### MEMORANDUM

SUBJECT: DRAFT: Jett SP-11-00004

Dan, I am forwarding you the draft requirements for the Jett Short Plat. Please forward to the applicant to allow them time to review and comment.

JETT SHORT PLAT

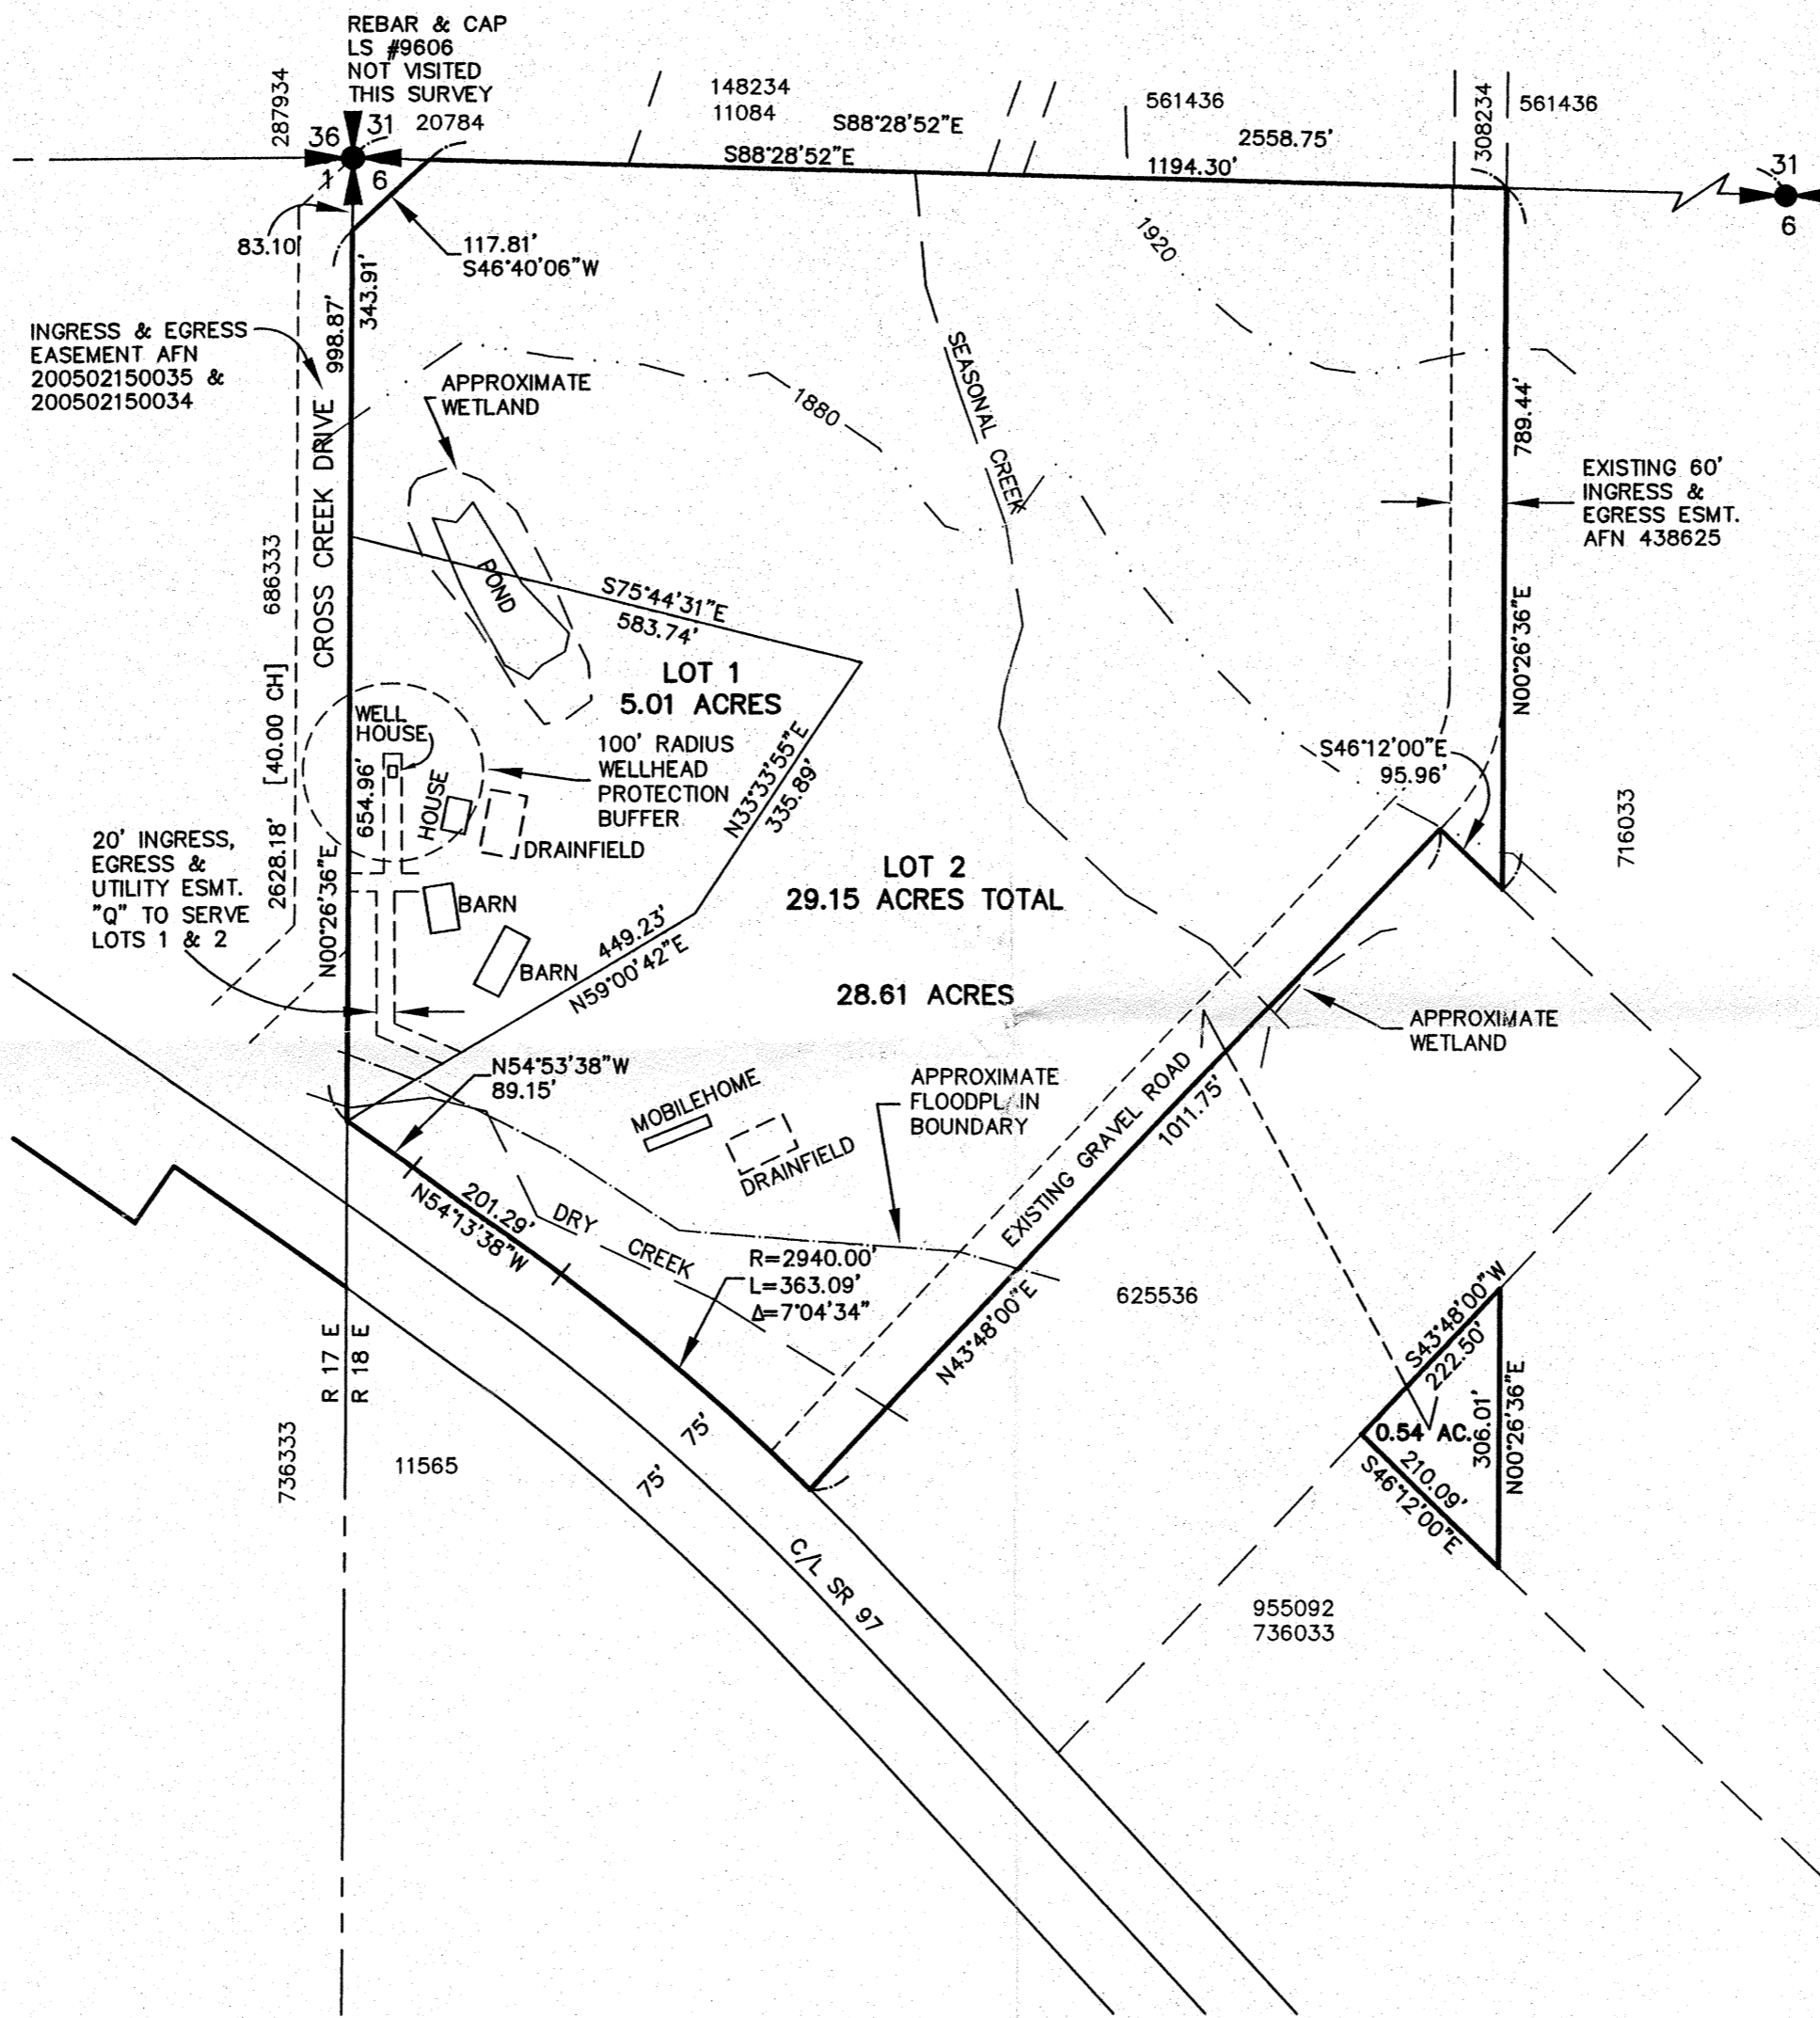
- Increase the road width to 22-feet from US 97 to the entrance to the plat.
  - Construct a hammerhead turnaround at the entrance to the plat.
  - Increase the crossing over Dry Creek to 20-feet in width.

3. Easement Width: The easement width of Cross Creek Drive shall be shown on the final plat.
  4. Private Road Improvements: Access from US 97 to the entrance to the plat shall be constructed as a Low-Density Private Road. See Kittitas County Road Standards, 9/6/05 edition.

- a. Access easements shall be a minimum of 60' wide. The roadway shall have a minimum width of 20', with 1' shoulders, for a total width of 22'.

5. Emergency Turnaround: A hammerhead turnaround shall be constructed on Cross Creek Drive at the entrance to the plat. The hammerhead must conform to the requirements specified by the 2009 International Fire Code. Contact the Fire Marshal regarding any additional cul-de-sac requirements.
